A66 Northern Trans-Pennine project Jan-Feb 2023 'Proposed changes consultation

I wish to lodge further firm objection to the proposal DC-05 appearing in the above consultation 'Removal of junction for Sewage Treatment Works (and private residence) from A66, and provision of an alternative access from B6262.'

Drawing Title: Classification of Roads Plan Regulation 5(2)(o)
 Sheet 1 of 1

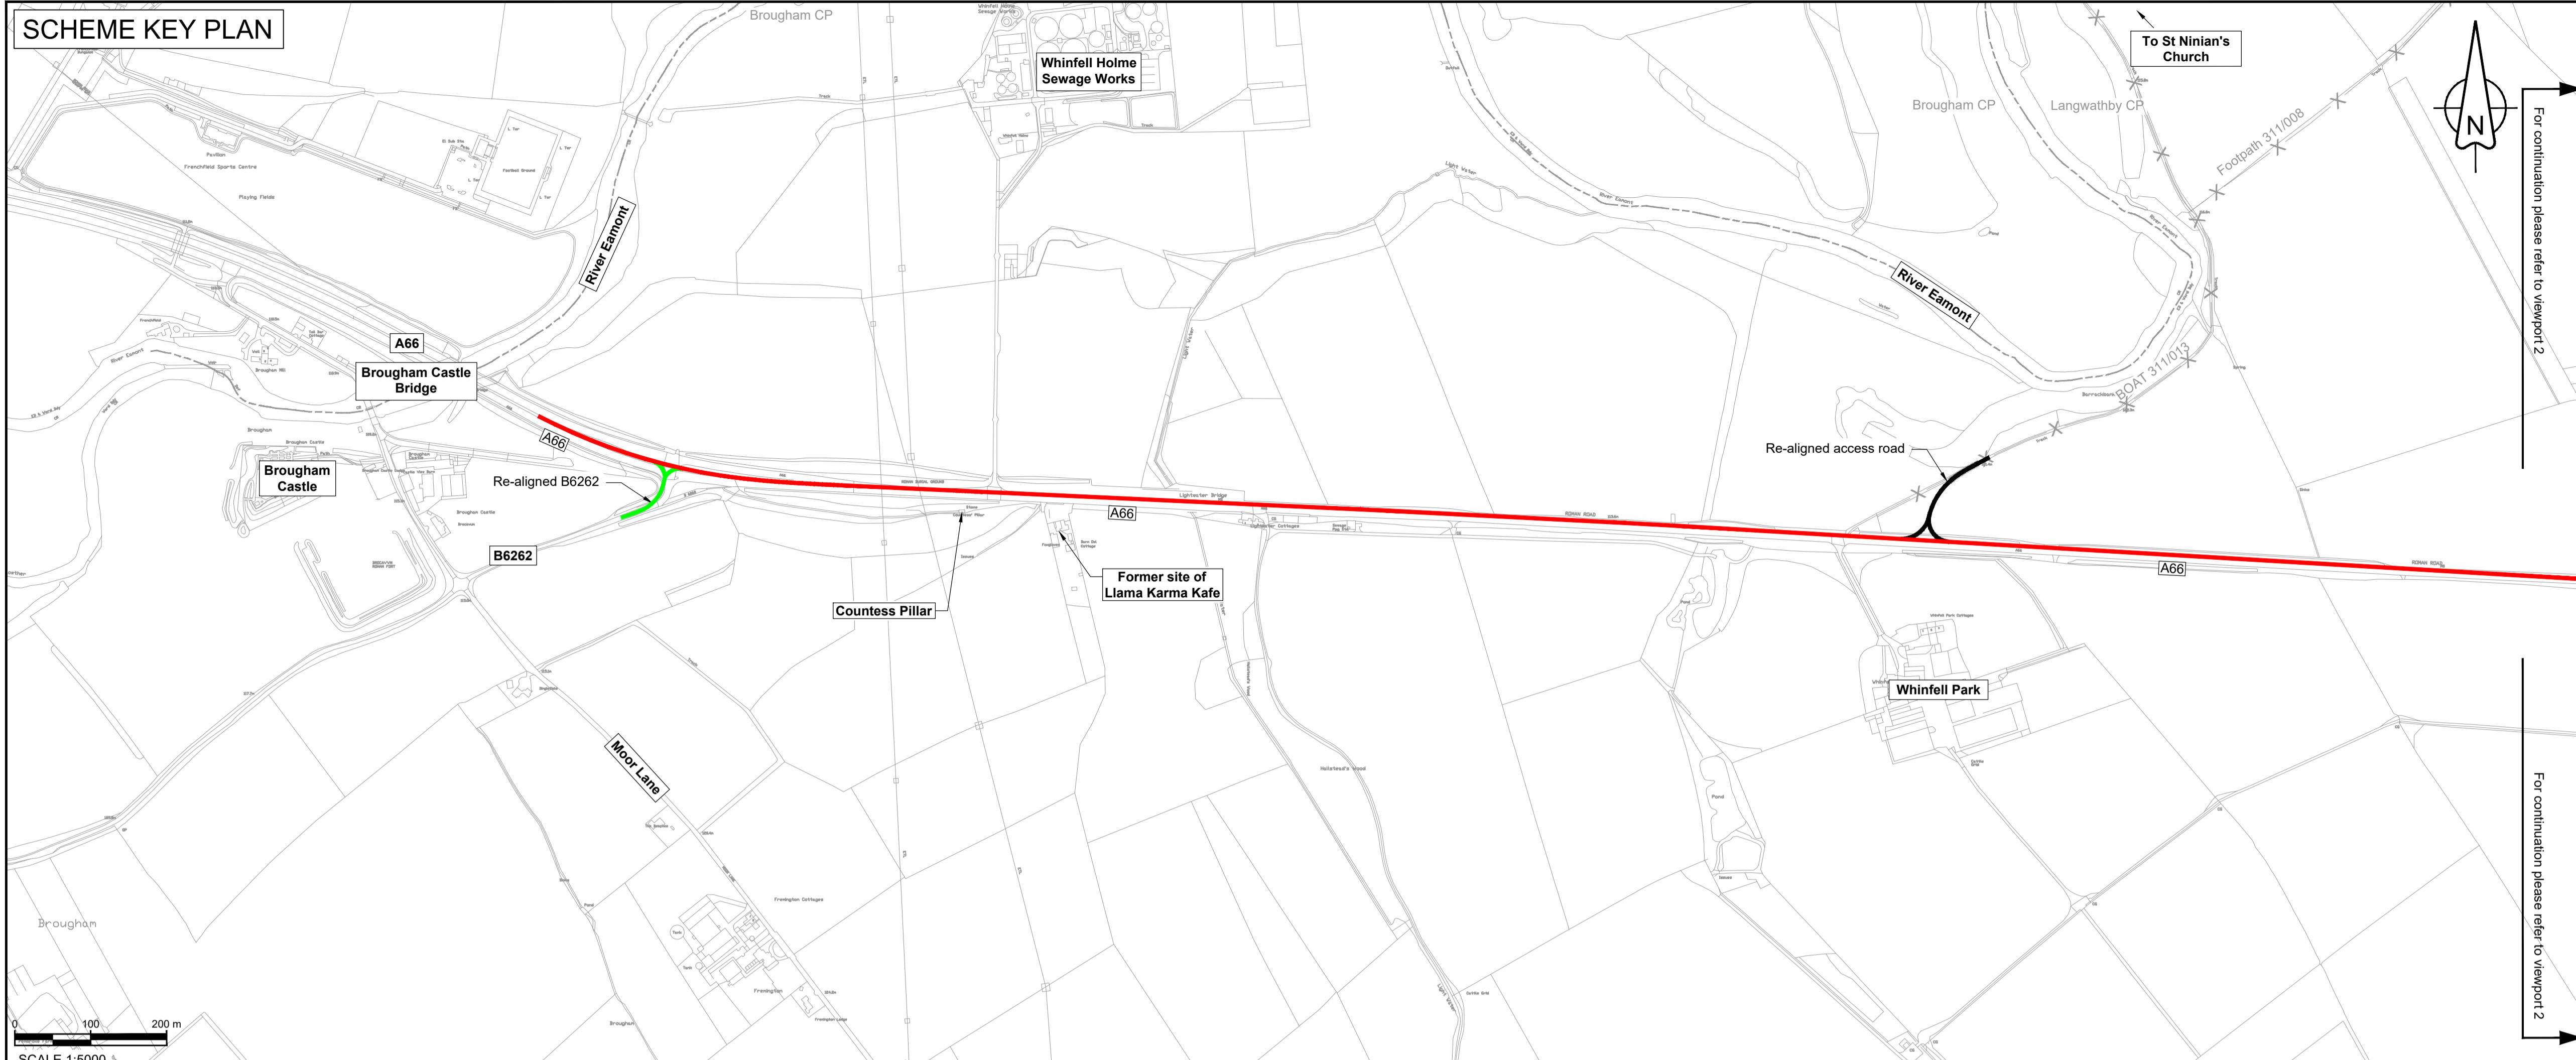
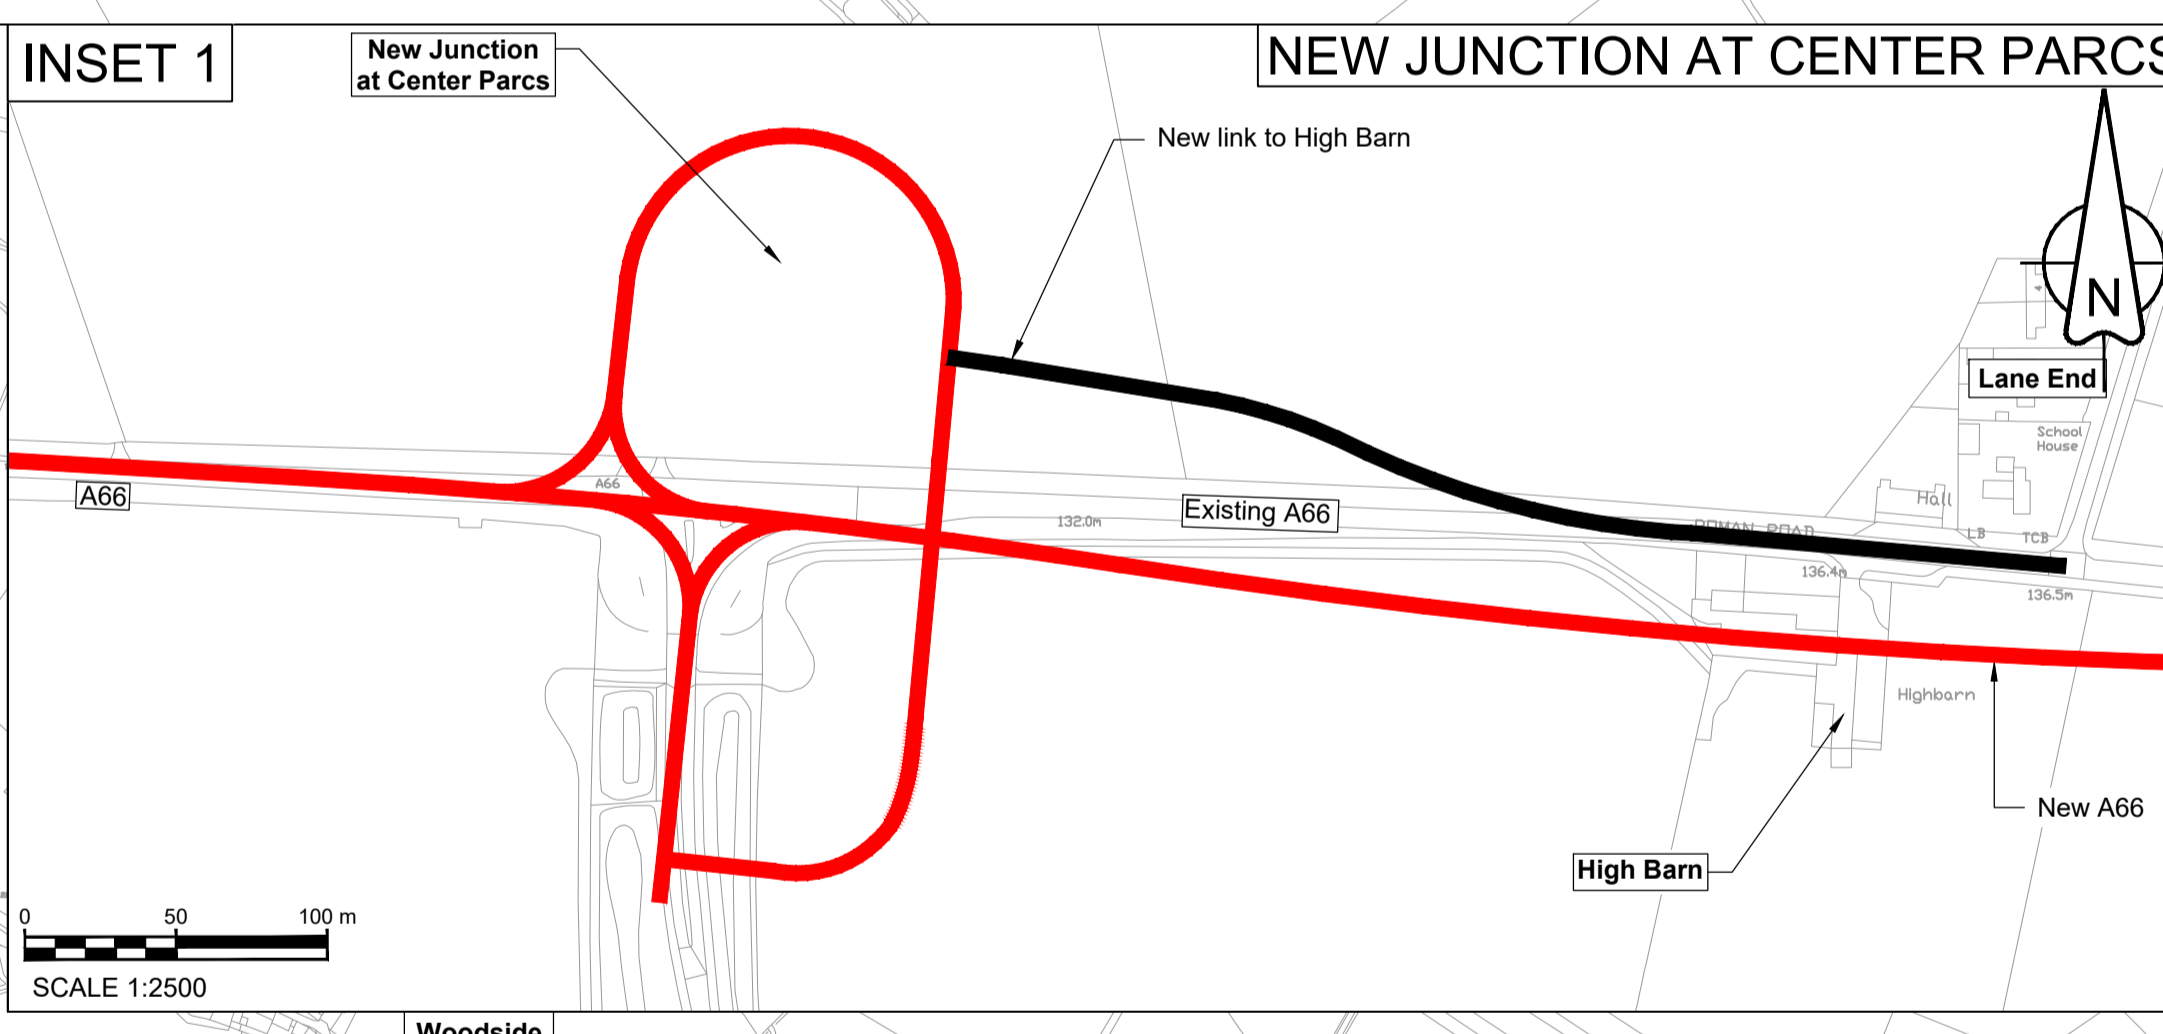
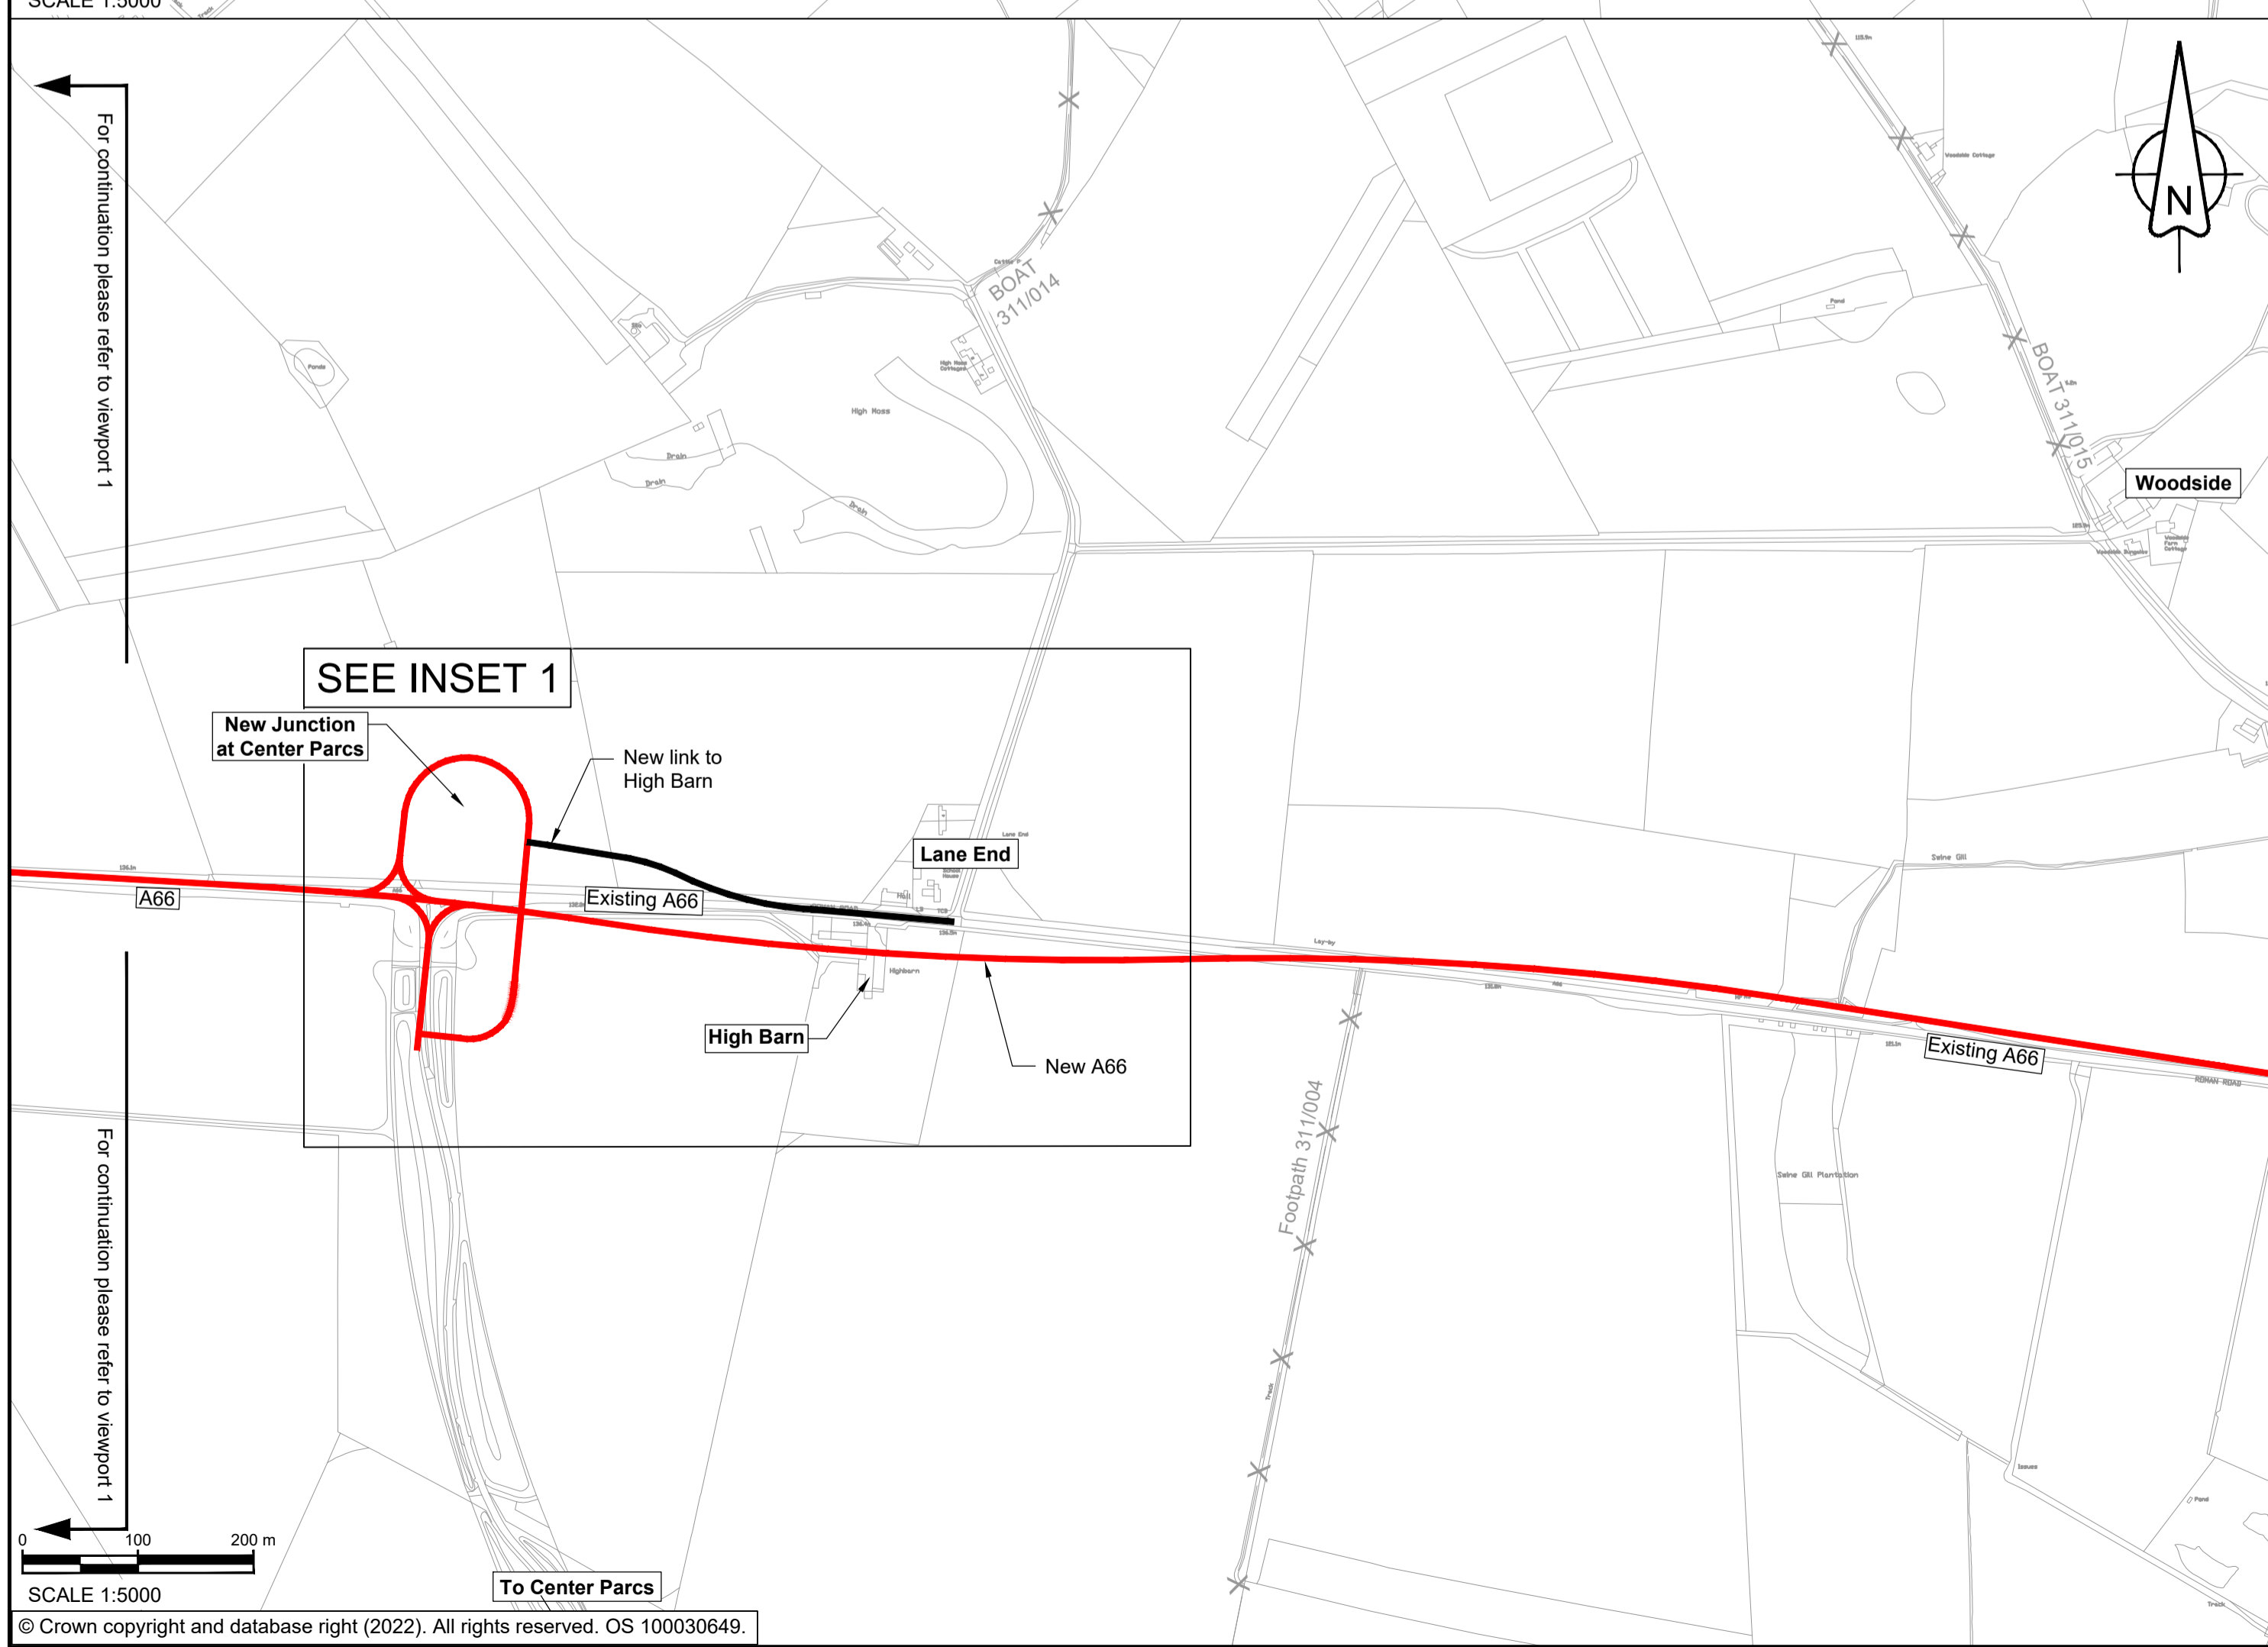
Now the B6262 is a narrow, often single carriageway road with sharp bends. As it passes Brougham Hall, the road not only narrows but also rises (or falls) steeply under a stone bridge of maximum height 12' 3". Having trunk road traffic, sometimes crawling, sometimes speeding along this road not built for purpose other than accommodating local residential traffic and the many pedestrians who use it for walking recreation, is a matter of profound concern. Moreover, this danger to life is now being experienced much more frequently. It occurs not only when there has been an accident or breakdown on the A6 or A66 but on a regular basis when congestion is caused by the sheer volume of holiday and working traffic throughout the year and particularly on Friday afternoons!

Of course, it can be argued that, on completion of the much needed major Northern Trans-Pennine project, these serious 'rat run' problems will be alleviated but they certainly will not be eliminated. However, this latest expensive DC-05 proposal to take HGV traffic (at least thirty lorries a day, we have been told) accessing the Sewage Treatment Works via a junction with the B6262 is asking for trouble. Even if it were possible to ensure Sewage Works traffic emerging from the proposed road crossing over the A66 on to the B6262 would be prohibited from turning left along this totally unsuitable minor road, the sharp right and left to attain the A66 westward, while cutting across local traffic turning off left to Brougham, is surely a road safety nonsense!

Furthermore, it has been confirmed by your officers that the same HGV traffic making its way **to** the Sewage Works will need carry on past their destination along the new eastbound carriageway and turn round at the Center Parcs roundabout over two miles further on! Their extra journey will amount to about five miles by the time they have negotiated the left turn on to the B6262 followed by the sharpest of left turns on to your proposed new road to the Sewage Works. Human nature being what it is, drivers are bound to try to avoid the 'merry-go-round' here described, by heading for Eamont Bridge and using the B6262 – an absolute NO-NO with the alternative of using the U3182 from Clifton Cross and then the B6262 also not on!
